# **KITITAS COUNTY**

## **DEPARTMENT OF PUBLIC WORKS**

### **MEMORANDUM**

TO: All Staff  
FROM: Justin Turnbull, County Surveyor   
DATE: June 2, 2020  
SUBJECT: County Survey Review of BL-20-00010 Shopbell

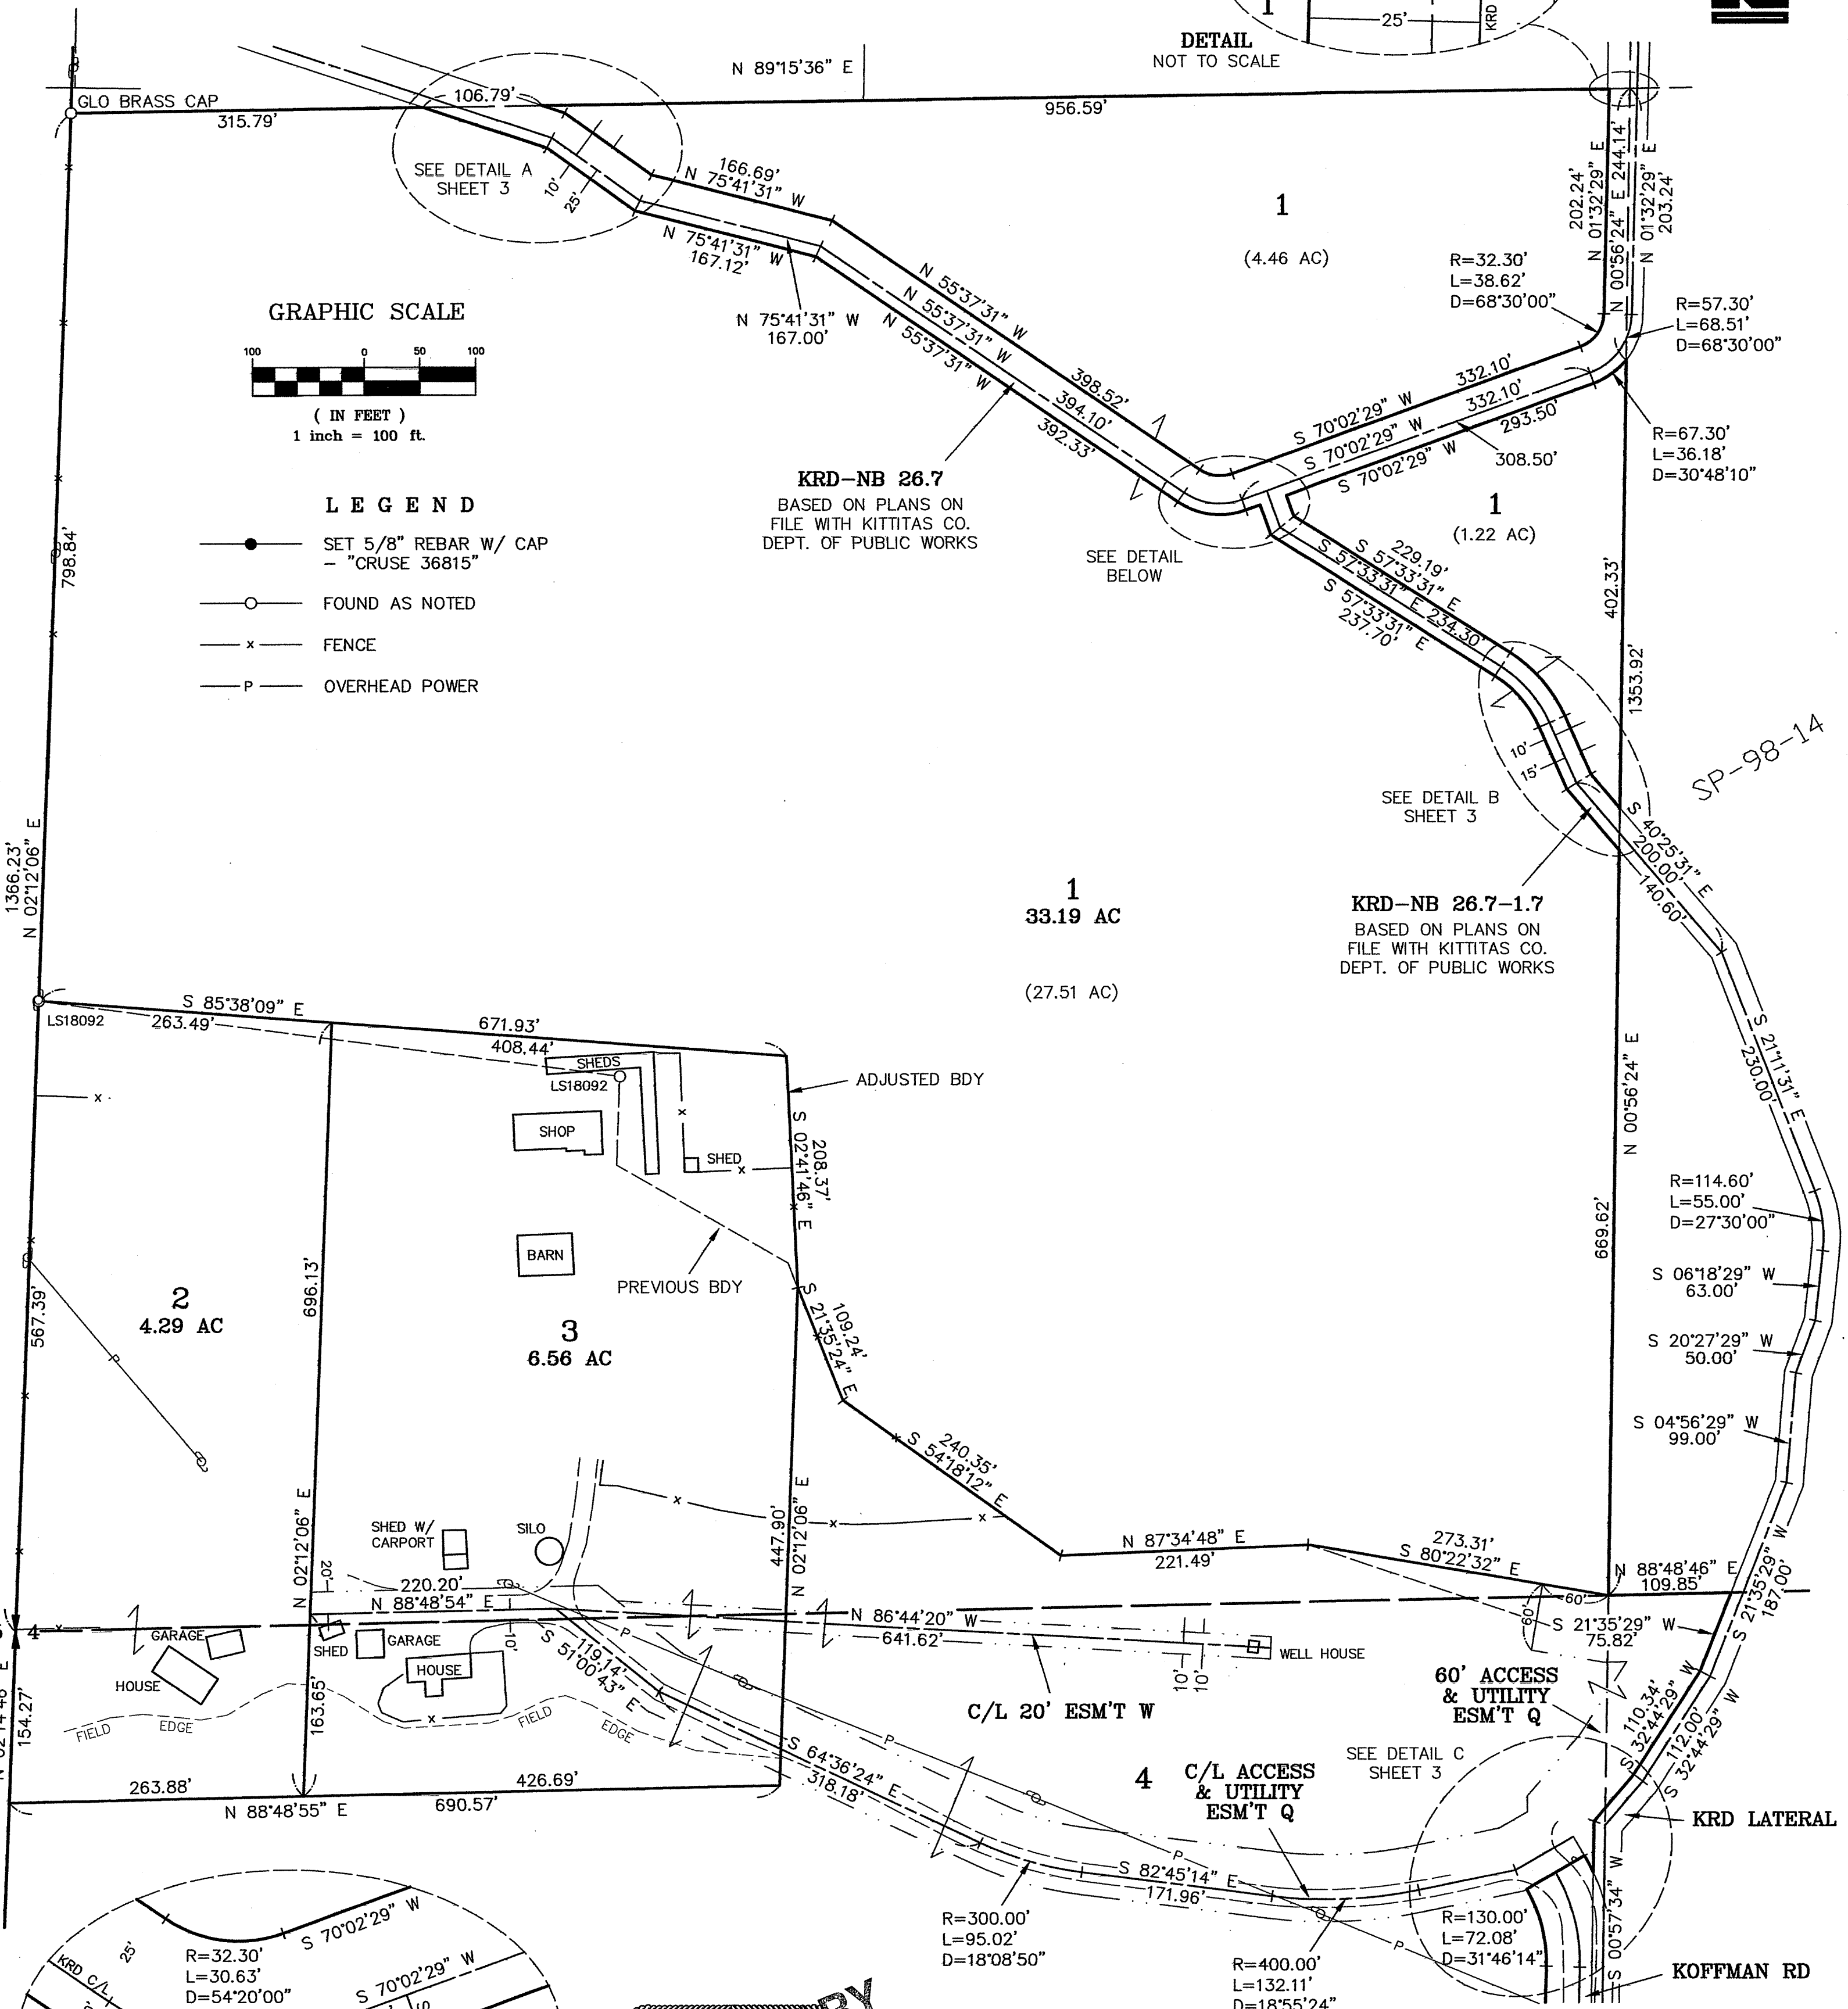
1. The boundaries of Lots 2 and 3, and the division line between Lots 1 and 4 should be staked and survey markers set and shown on the map.

Note: While county code calls out ALL property corners to be marked, I am of the opinion that canals and roads act as natural boundaries, and monumenting these are unnecessary in this case.
